## **AQUIND INTERCONNECTOR**

Consultation Report – Appendix 1.7I Marine  
Specific – Briefing Note for Ongoing  
Consultation with British Marine Aggregates  
Producers Association September 2019

Document Ref: 5.1.7I

Natural Power Memorandum			
To	BMAPA	Date	September 2019
From	Natural Power	Ref.	1199528

TITLE:
Figure 9.6 South Marine Plan

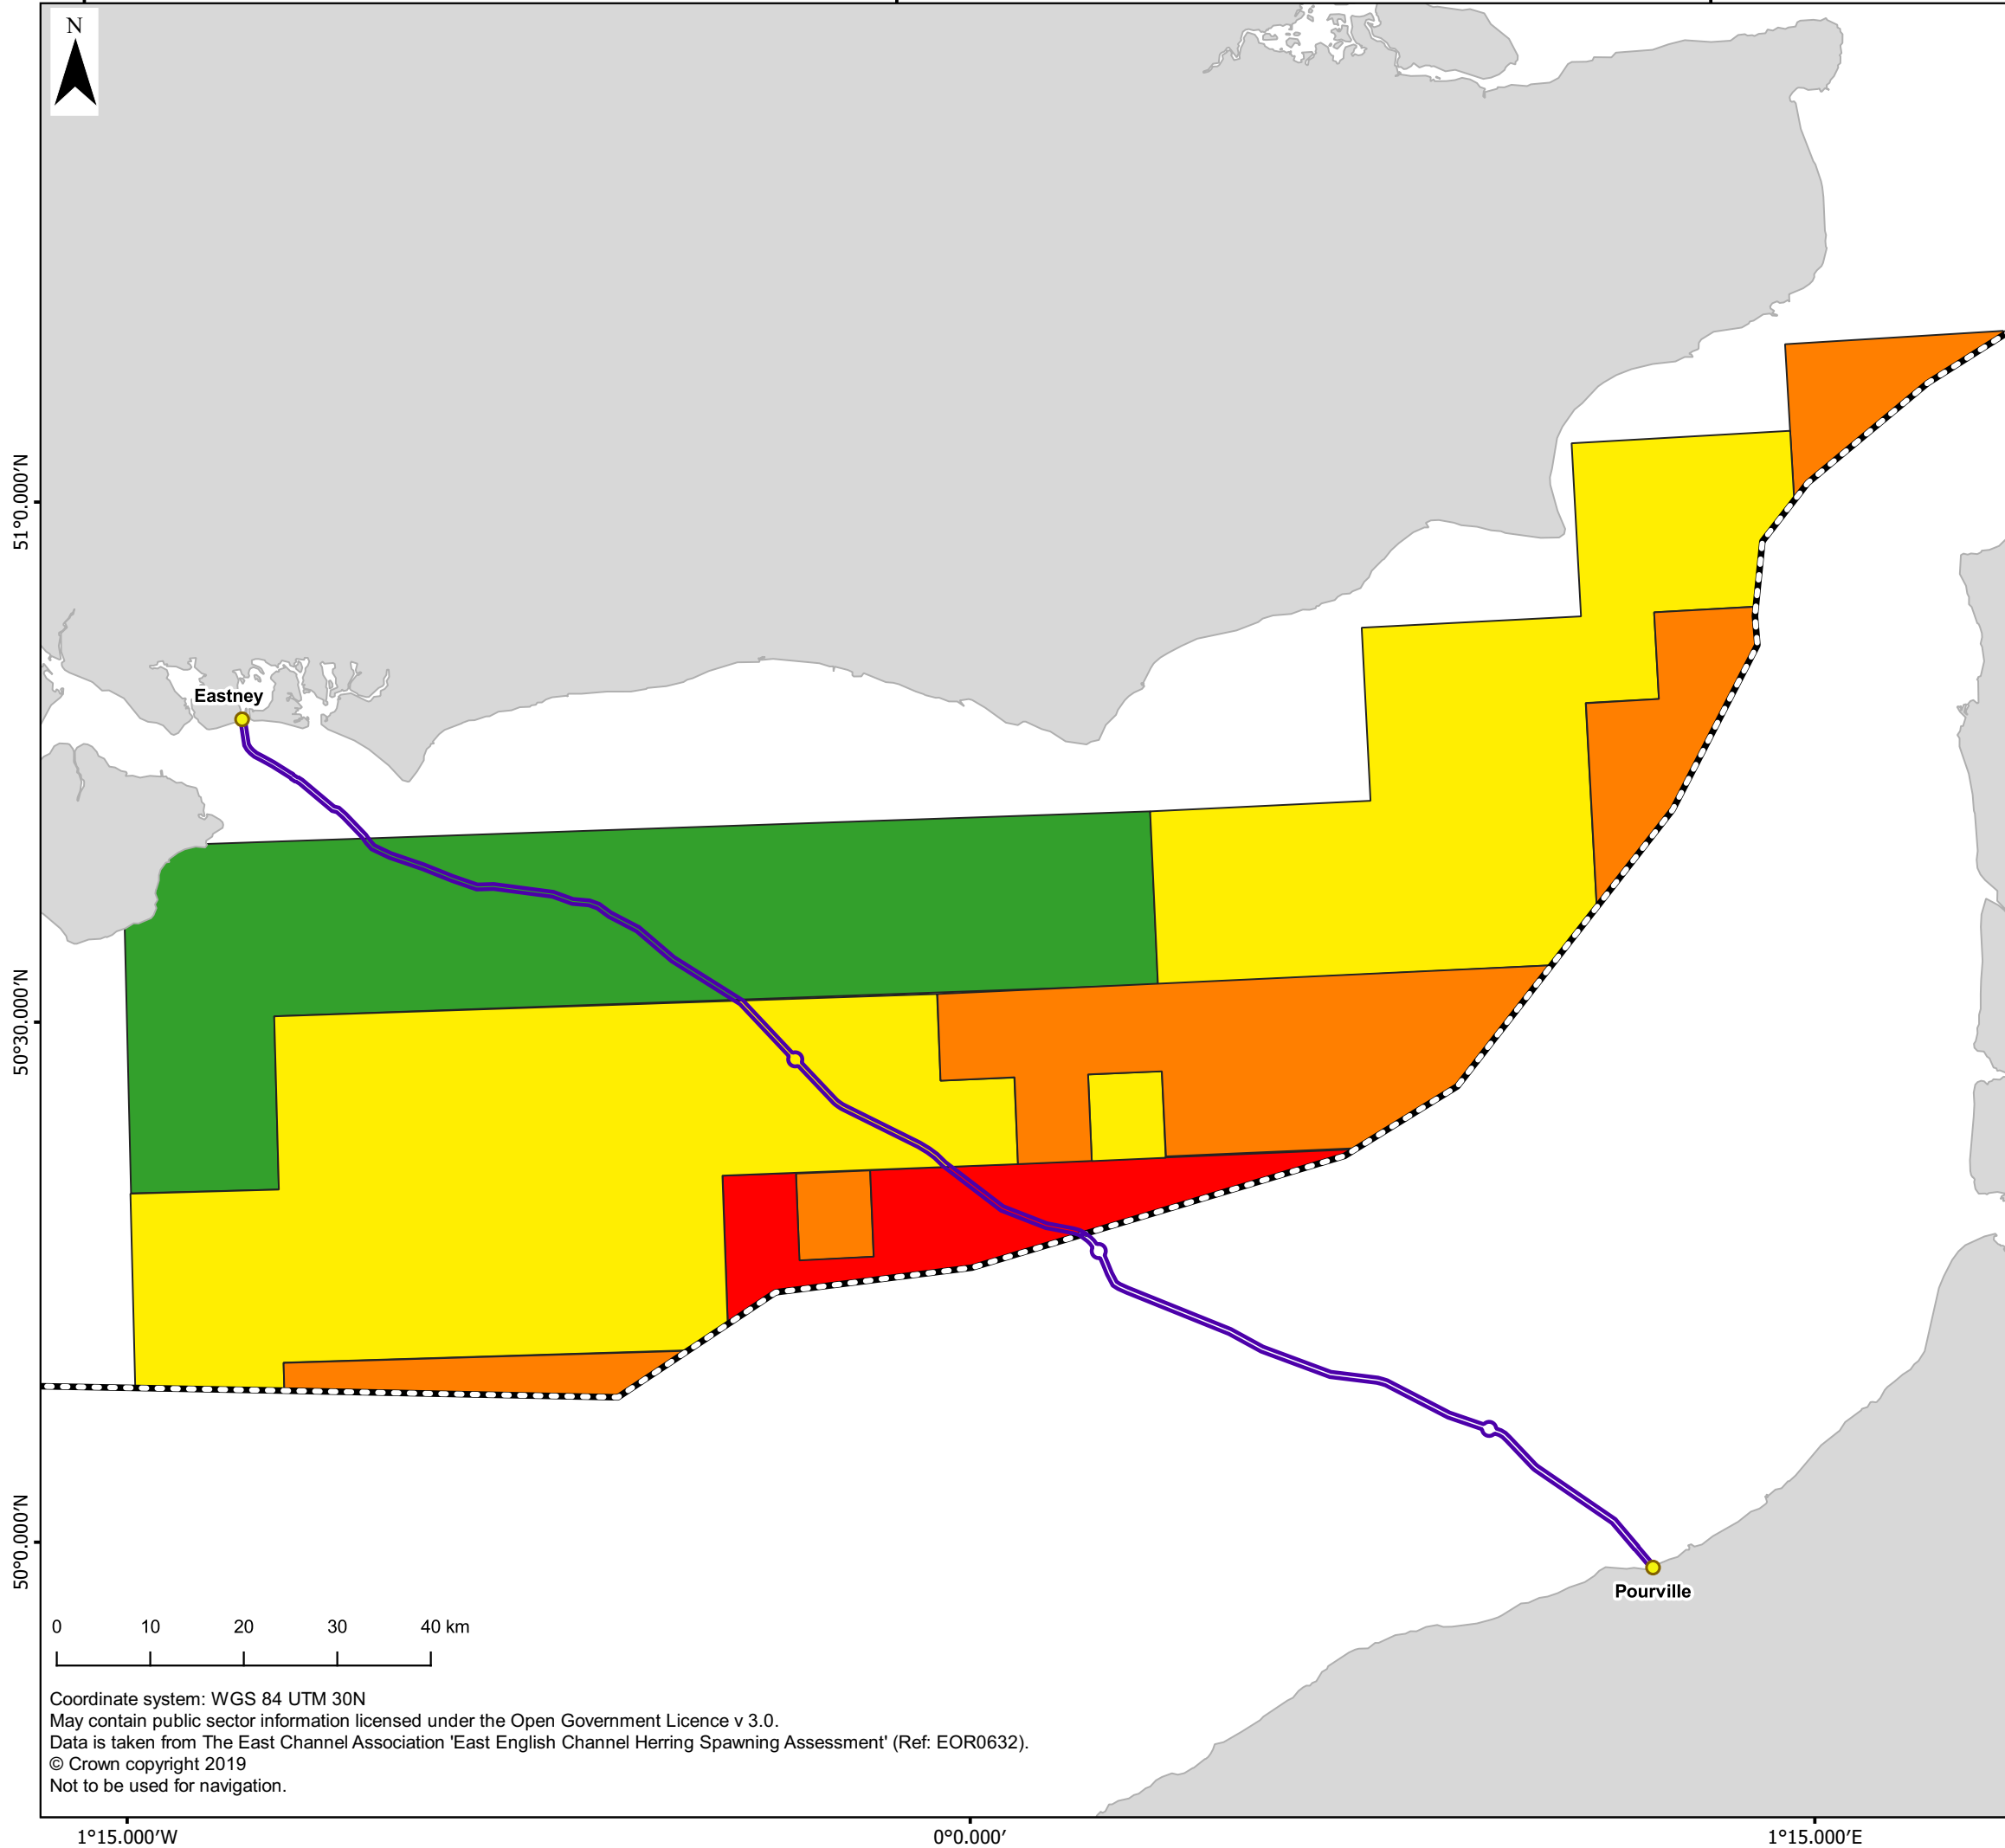
Item	Topic	Comment	Applicant's Response
1	Shipping, Navigation and Other Marine Users	The distribution of commercially viable marine sand and gravel resources is highly limited, constrained by their geological distribution and their geographical position relative to the markets location. Consequently, with the growing pressures and demands being placed on marine space, it is essential that existing marine aggregate interests (production licences, applications and option areas) are provided adequate protection against new developments that may interfere with their ongoing safe operation through the policies provided in the relevant marine plans that are in place. Equally, given the limited spatial extent of marine sand and gravel deposits, it is also important that areas of potential future resource are clearly identified and flagged so they can equally be considered through the relevant safeguarding policy provisions provided in marine plans – particularly given future resource demands and requirements will inevitably evolve and change over the 20 year plan period and beyond.	<p>Discussions have been ongoing with the aggregate dredging companies most likely to be impacted by the works: Cemex, Volker and Tarmac. Tarmac have indicated that they have no significant concerns regarding the routing of the marine cable. Volker Dredging Ltd have also indicated that the use of a 1 nautical mile buffer around their dredging interests would protect their dredging areas. Cemex have also indicated that they do not have significant concerns regarding the Proposed Development.</p> <p>In order to minimise impacts to the aggregate industry, early engagement was undertaken with dredging companies and The Crown Estate. As a result, the cable route was refined to avoid current aggregate dredging interests such as the former Horsetail dredging area and the route was also moved closer to IFA2 to avoid rocky seabed/fishing grounds and minimise 'sterilisation' of the seabed between the two proposed cables (AQUIND Interconnector and IFA2).</p> <p>There has been regard to potential future areas of interest including through engagement with The Crown Estate, whose current leasing round does not indicate that any of the proposed leasing areas will be along the route of the Proposed Development. The Crown Estate has been consulted, and in their investigations of the potential for</p>

2	Shipping, Navigation and Other Marine Users	<p>In this respect, we consider that the background marine mineral resource data prepared by the British Geological Survey represents an incredibly valuable dataset, not only in terms of defining where the industry may want to go in the future, but also in highlighting where it is unlikely to go. See: <a href="https://www.bgs.ac.uk/mineralsuk/planning/resourceOffshore.html">https://www.bgs.ac.uk/mineralsuk/planning/resourceOffshore.html</a> And: <a href="http://www.marineaggregates.info/downloads-and-links/bgs-mineral-resources-studies.html">http://www.marineaggregates.info/downloads-and-links/bgs-mineral-resources-studies.html</a></p>	<p>AQUIND has used the most recent up to date data available for determining the composition of the seabed which has been ground truthed through project specific marine surveys for the Proposed Development.</p> <p>It should be noted that The Crown Estate have not raised any concerns regarding the impact of the Proposed Development on the future of marine aggregate areas of interest.</p>

3	Shipping, Navigation and Other Marine Users	<p>We note that the current assessment only considers the potential impacts of the proposed route on existing licensed marine aggregate interests. We further note that no reference has been made to the existing guidance that</p>	<p>The ESCA guidance states that is “<i>generally considered that any aggregate extraction zone outside of 1NM (1.852km) will have a minimal impact</i>”</p>

4	Shipping, Navigation and Other Marine Users	<p>No consideration has been given to the potential for the proposed project to impact on those areas of marine sand and gravel resource that may be considered for use in the future.</p>	<p>Consideration has been made to possible impacts on aggregate resource in addition to existing licensed areas, including consideration of future leasing areas. Potential areas of interest for future use are considered by The Crown Estate, and the current leasing round (started May 2019) does not indicate that any of the proposed leasing areas will be along the route of the Proposed Development. The Crown Estate has been consulted and has not raised any concerns with the potential for future areas around the Proposed Development.</p>
5	Marine Local	<p>The Marine Policy Statement (para.3.5.6) states that, amongst other considerations, marine plan authorities and decision-makers should: <i>'...take into account the need to safeguard [aggregate] reserves for future extraction'</i>.</p> <p>Policy S-AGG-3 of the South Marine Plan (HM Government, July 2018) applies the Marine Policy Statement taking account of the regional and national importance of the plan area for marine aggregate supply and the spatially discrete areas in which commercially viable deposits of sand and gravel are found. The policy is intended to enable public authorities to consider how proposals for marine development and activities within areas of high potential aggregate resource, as defined by</p>	<p>The DCO application will include detail of how we have had regard to the South Marine Plan and policies including the relevant marine aggregates policies.</p> <p>It should be noted we are required to have regard to a range of policies in the South Marine Plan (not just aggregate policies) including as those relating to protecting marine protected areas and fish resource and commercial fishing; which also have a preference for avoidance of certain areas.</p> <p>The project design process has taken measures to account for possible effects on the aggregate industry, and through refinement, the route has been further optimised closer to shore and</p>

6	Shipping, Navigation and Other Marine Users	<p>Where cable infrastructure is found to coincide with commercially viable marine sand and gravel resources, the default position should be a commitment for any permanent constraint on the ability to use that resource in the future to be removed in its entirety once it reaches the end of its commercial life.</p>	<p>As stated in Section 3.2.10 of Chapter 3 (Description of the Proposed Development) of the Environmental Statement, the decommissioning of the marine cable will be determined by the relevant legislation and guidance available at the time of decommissioning. A decommissioning plan will also be developed and agreed with The Crown Estate. The Development Consent Order / Deemed Marine Licence will not grant approval for the decommissioning of the marine cable and as such a separate marine licence may be required closer to the time of decommissioning and production of the decommissioning plan.</p> <p>At the time of decommissioning, the options for decommissioning the cable will be evaluated and could include consideration of leaving the marine cable in situ, removal of the entire marine cable or removal of sections of the marine cable. These options will be</p>

Item	Topic	Comment	Applicant's Response
			<p>impact to future resource, they have not raised any concerns about potential impacts resulting from the Proposed Development. The Applicant has a signed Option Agreement and agreed Licence with The Crown Estate. Similarly, the aggregate companies consulted have not raised concerns about any impacts from the Proposed Development to future aggregate resource areas of interest.</p> <p>More broadly with regards to Marine Plans, direction was provided by the Secretary of State in July 2018 that the AQUIND Interconnector is a Nationally Significant Infrastructure Project (NSIP) and therefore National Policy Statement (NPS) EN – 1 provides the primary basis for decision making, whilst regard should be made to relevant Marine Plans. Further detail on how the Proposed Development has had regard to the South Marine Plan will be provided as part of the Development Consent Order (DCO) application.</p>

Item	Topic	Comment	Applicant's Response
		<p>has been produced by the European Subsea Cable Association (ESCA Guideline No.19, 2016) which establishes proximity guidelines to address the potential interaction between subsea cables and marine aggregate interests - <a href="https://www.bmapa.org/documents/Guideline_19_Marine_Aggregate_Extraction_Proximity_2.pdf">https://www.bmapa.org/documents/Guideline_19_Marine_Aggregate_Extraction_Proximity_2.pdf</a></p>	<p><i>upon a submarine cable.</i>" The route of the Proposed Development has been refined through further design work and through consultation with The Crown Estate, aggregate dredging industry and fishermen and has been refined to provide a 1nm buffer from all aggregate interests which will protect, not only the Proposed Development from aggregate dredging activities but will also protect the aggregate interests from the construction of the Proposed Development.</p>

Item	Topic	Comment	Applicant's Response
		<p>British Geological Survey, may impact the ability to access commercially viable marine sand and gravel resources in the future. In turn, this is intended to help maintain access to sufficient supply of aggregate resources in the future. This is further supported by the general policy for co-existence (Policy S-Co-1), which requires 'Proposals will minimise their use of space and consider opportunities for co-existence with other activities'. Therefore, in order to comply with the marine mineral safeguarding policies in the South Inshore/Offshore Marine Plans (particularly policy S-AGG-3), which in turn reflect the requirements of the UK Marine Policy Statement, we consider it necessary for both the routing plan and the decommissioning programme for the AQUIND interconnector to take full and proper account of the potential for marine mineral resources to be permanently sterilised over the long term.</p>	<p>approximately halfway along the route, following discussion with The Crown Estate, the aggregate dredging industry and fishermen.</p> <p>Chapter 2 (Alternatives) of our Environmental Statement provides details of this process, including how the cable route was refined in mid-channel, not only to cross the main shipping corridors more safely but also to avoid existing aggregate areas. The nearshore revision avoided, as far as possible, the former Horsetail dredging area, and moved the route closer to IFA2 to avoid rocky seabed/fishing grounds and minimise 'sterilisation' of the seabed between the two proposed cables (AQUIND Interconnector and IFA2).</p>

Item	Topic	Comment	Applicant's Response
			<p>evaluated against the relevant decommissioning guidance available at the time and environmental implications, safe navigability of the area for other sea users and liability risks. A similar process will be undertaken for other infrastructure installed as part of the Proposed Development i.e. non-burial cable protection.</p>
7	Marine Local	<p>More generally, we are surprised at the limited references that are made to the South Marine Plan and its associated policy requirements as they relate to existing uses and activities, given the requirement for decisions relating to NSIP projects to have regard to these.</p>	<p>The DCO submission to the Planning Inspectorate will provide further detail of how we have had regards to the relevant policies of the South Marine Plans as well as the NPS.</p>
